From: Amanda Scholes on behalf of Planning.Responses
Sent: 17 October 2019 12:49
To: Planning Scanning
Subject: FW: BR/120/19/PL, BR/121/19/L, The Bandstand

Subject: BR/120/19/PL, BR/121/19/L, The Bandstand

RAILING REPLACEMENT / REPAIR  
DETAILS - SHEET 1 OF 2

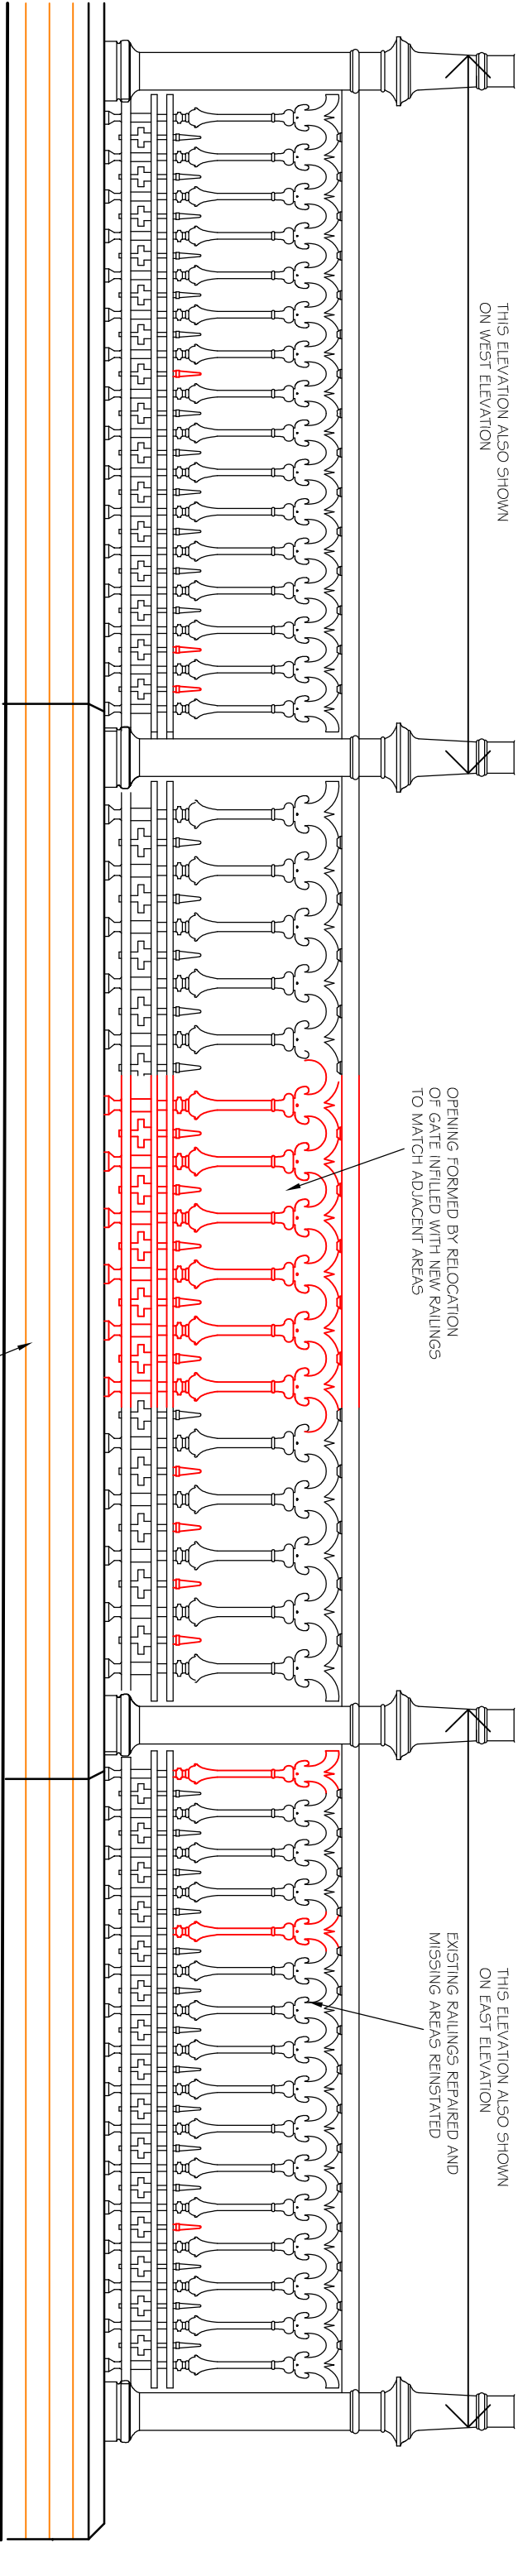
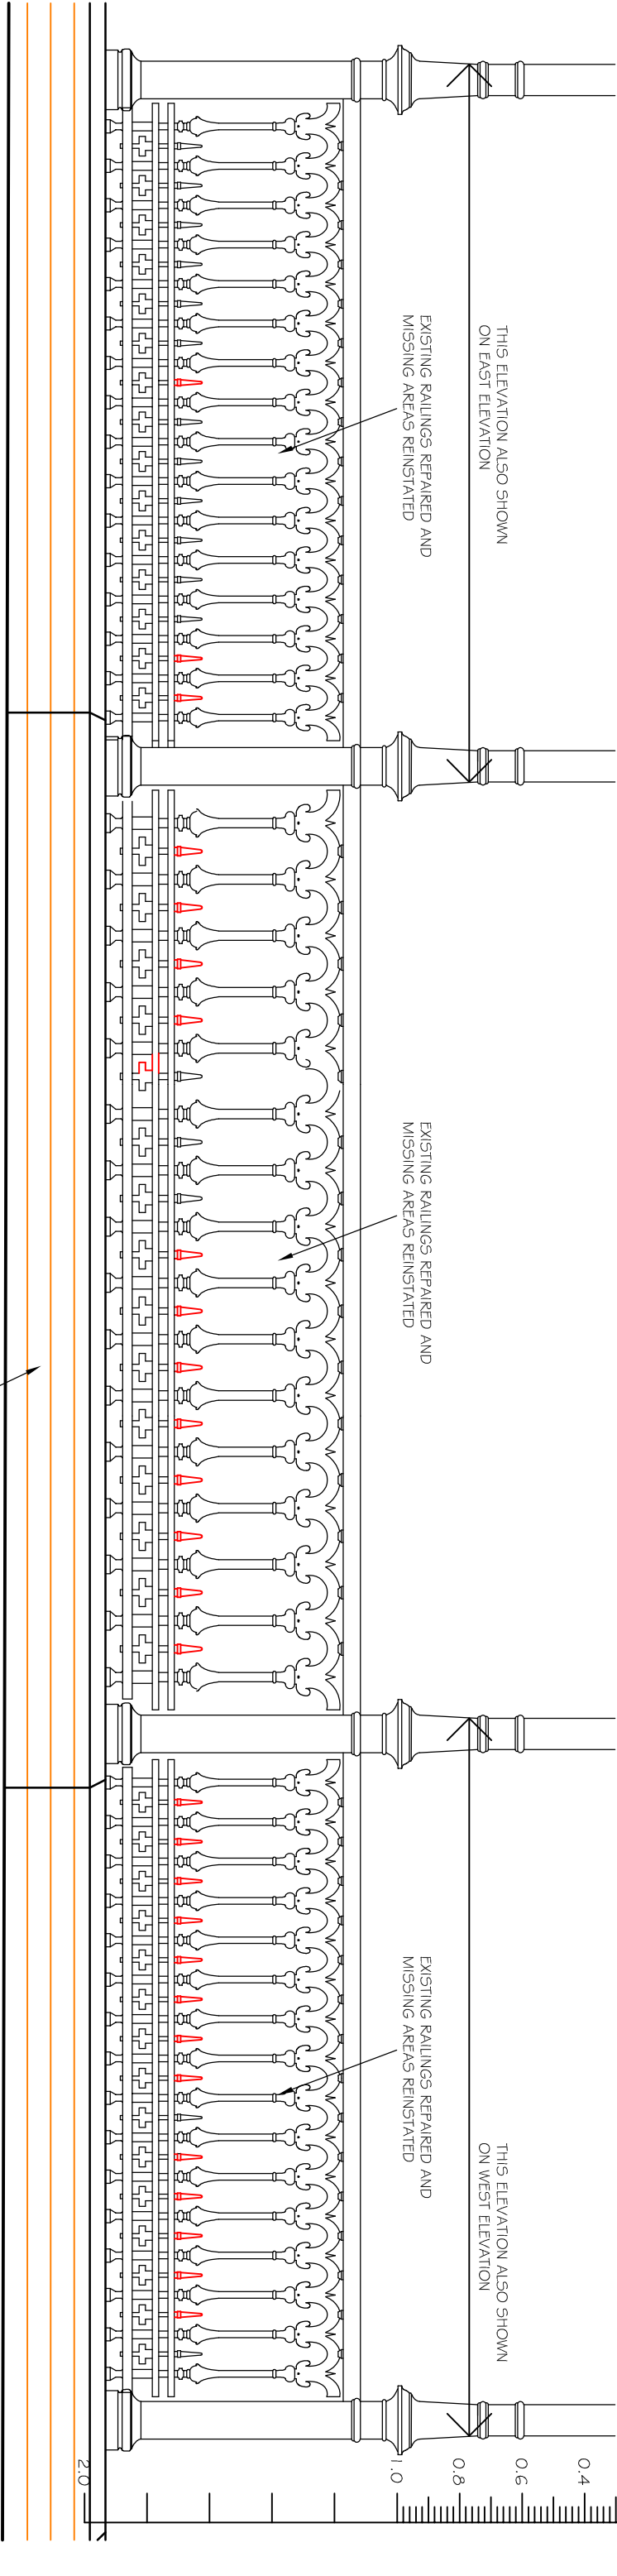
However, there are some issues which require clarification. It is not clear from reviewing the information why the location of the gate is to change.

Further, scant information has been provided regarding the proposed Perspex sheeting; how will it be fixed to the structure? Will it form a permanent element of the structure, or will it be used on a temporary basis (and removed when not required)? Further, what size will the panels be? What would the quality of the materials used be? At present, such an issue is considered to be problematic.

- **Relocation of access gate.** The Bandstand has previously been disassembled and re-assembled and is not in its original location. There is no particular historic or architectural significance related to the current positioning of the access gate except that it faces directly onto the seafront. The balustrading and handrail (and associated access gate) are relatively interchangeable between the main structural support posts as the structure is a regular, symmetrical shape. The relocation of the gate will position it where there is currently an access step, which would seem an entirely logical location as this position would enable easy access and egress without disturbing the main thoroughfare along the promenade.

- **Perspex sheeting.** I can confirm the Perspex sheeting that was proposed to the metal railings has now been omitted from the proposals.
The proposed Perspex sheeting at high level will be fitted on the inside face of the decorative ironwork and is required to prevent rainwater penetration into the roof structure and onto the proposed ceiling. This Perspex sheeting will be clear and would barely be visible from ground level. It will be fixed in a manner to enable removal on a future occasion to ensure the work is entirely reversible.

DWG NO 824/04

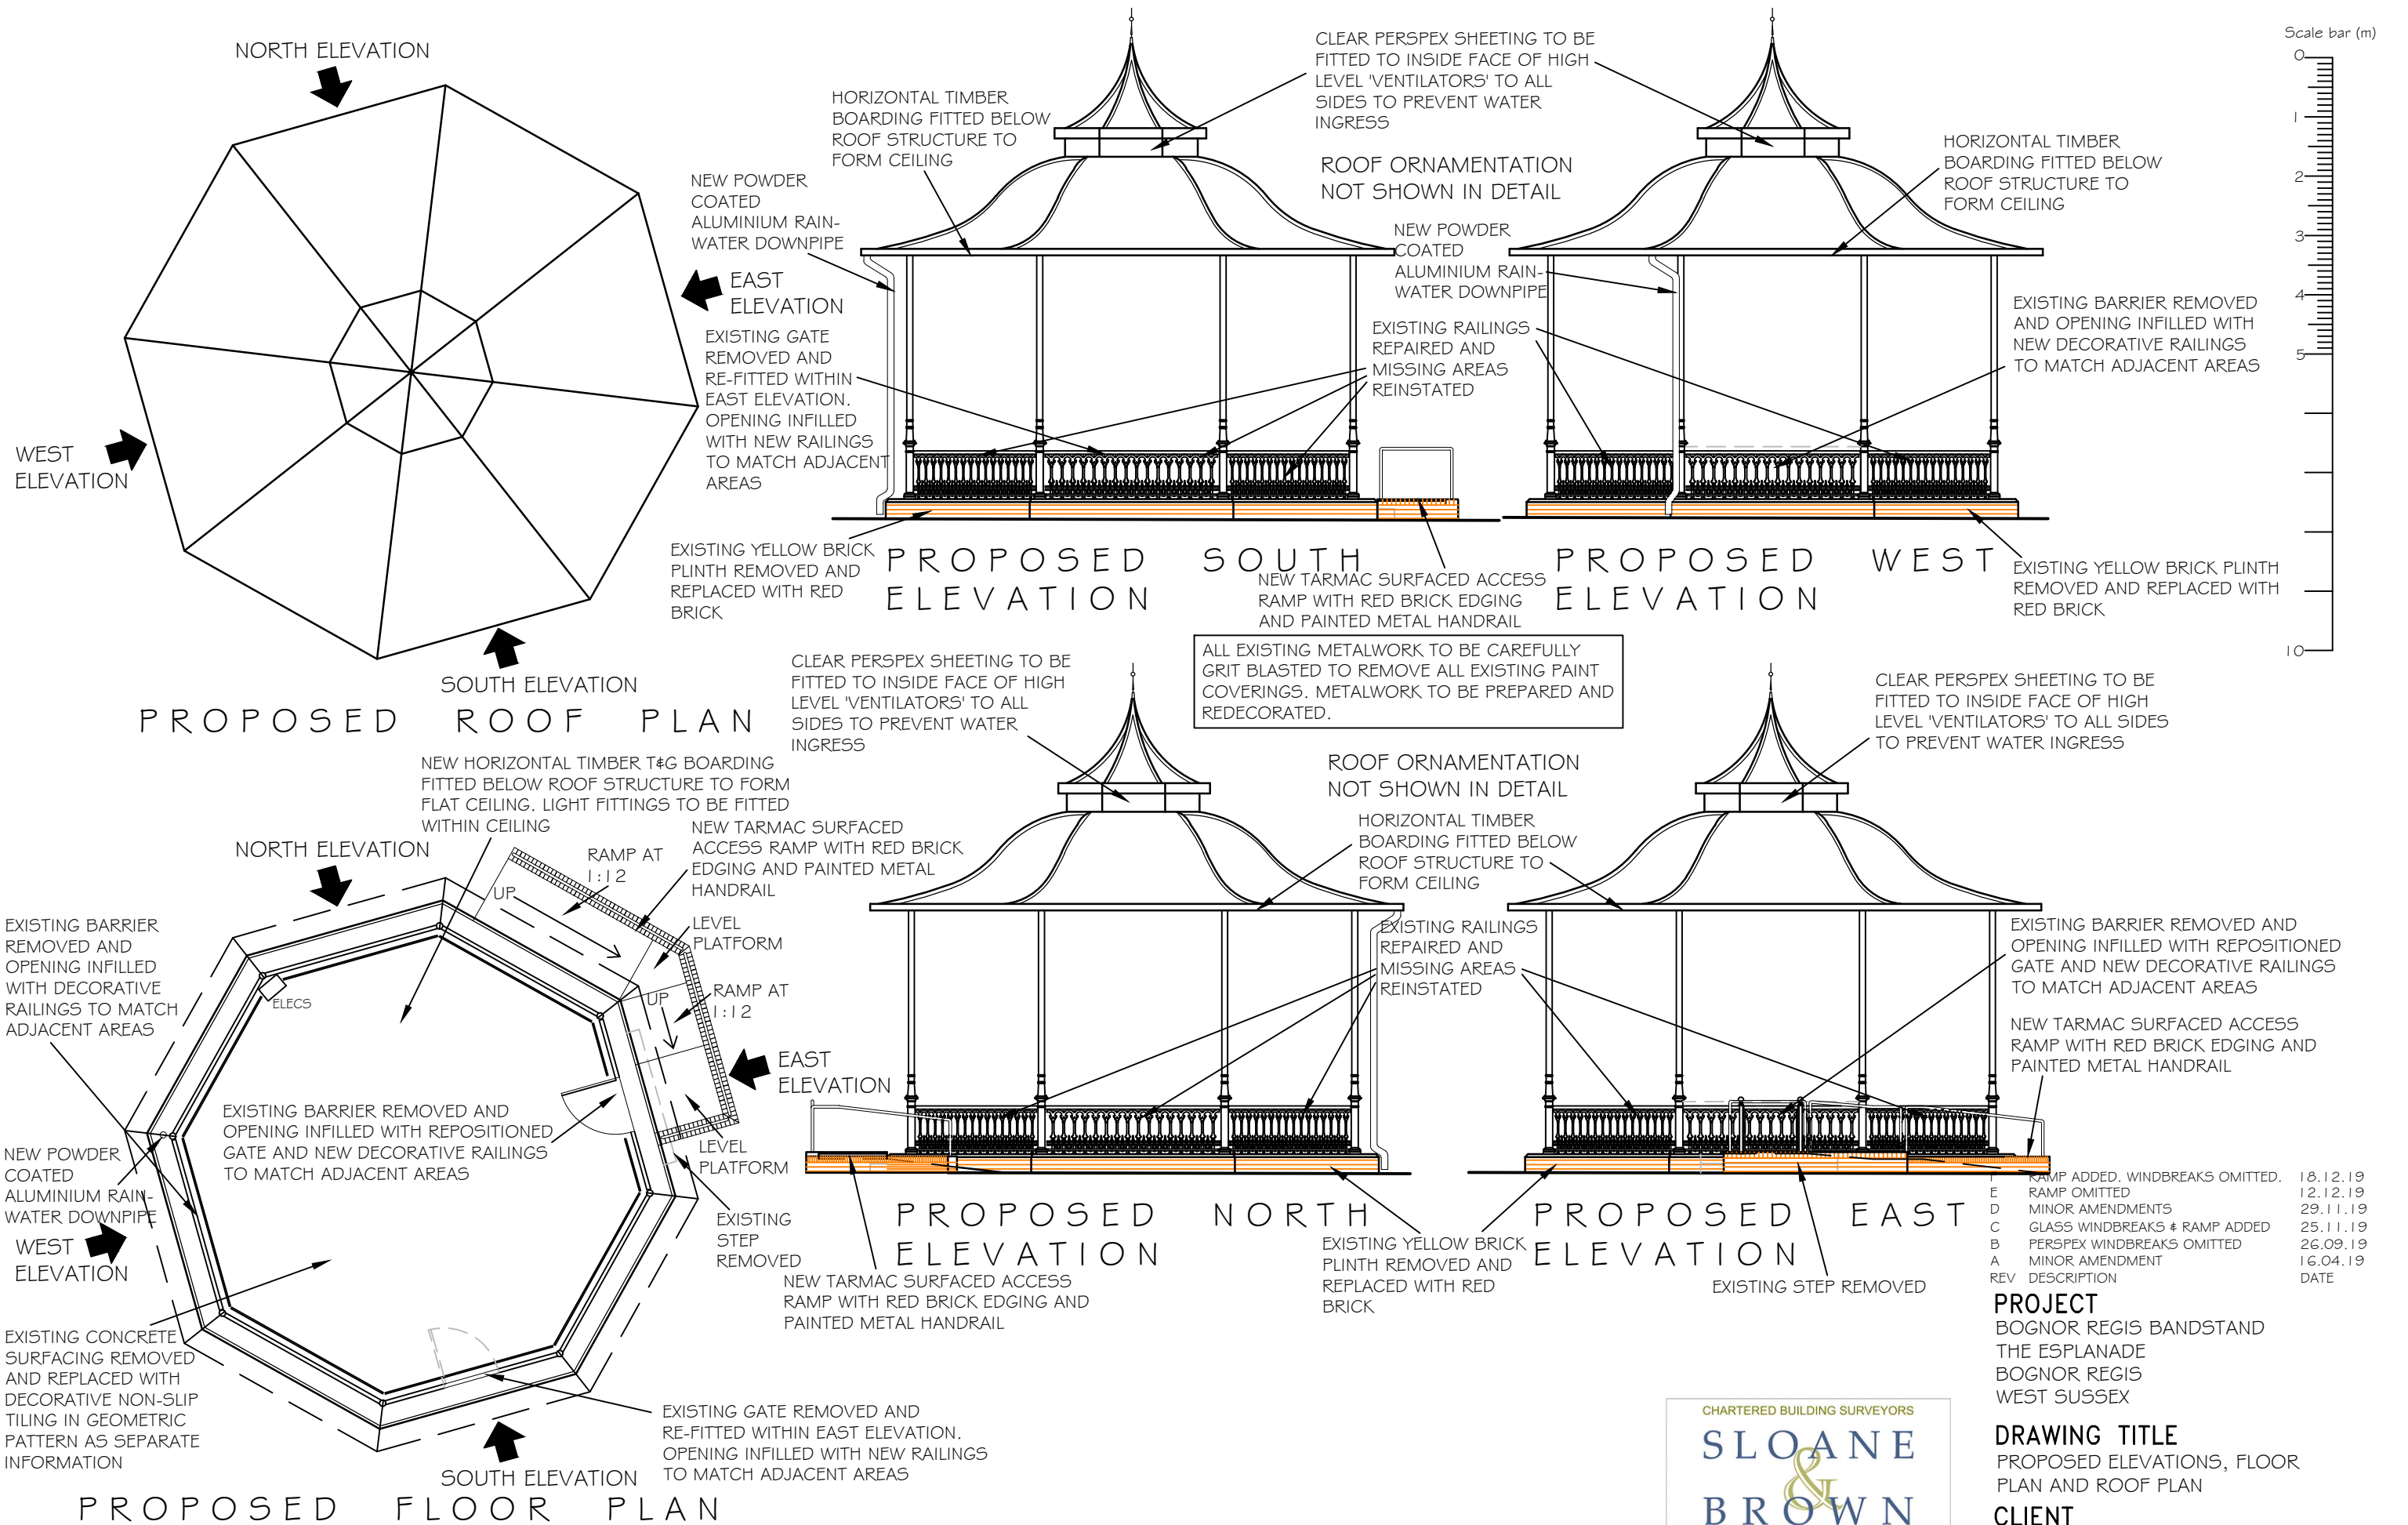
Also how will the horizontal timber boarding to be fitted below the roof structure to form a ceiling be treated?

- **Timber ceiling boarding.** The new timber boarding will be fitted to existing horizontal metal framework and would have a painted finish.
- **Materials.** We accept that a suitably worded condition will need to be applied to agree the details of the new bricks and other items.
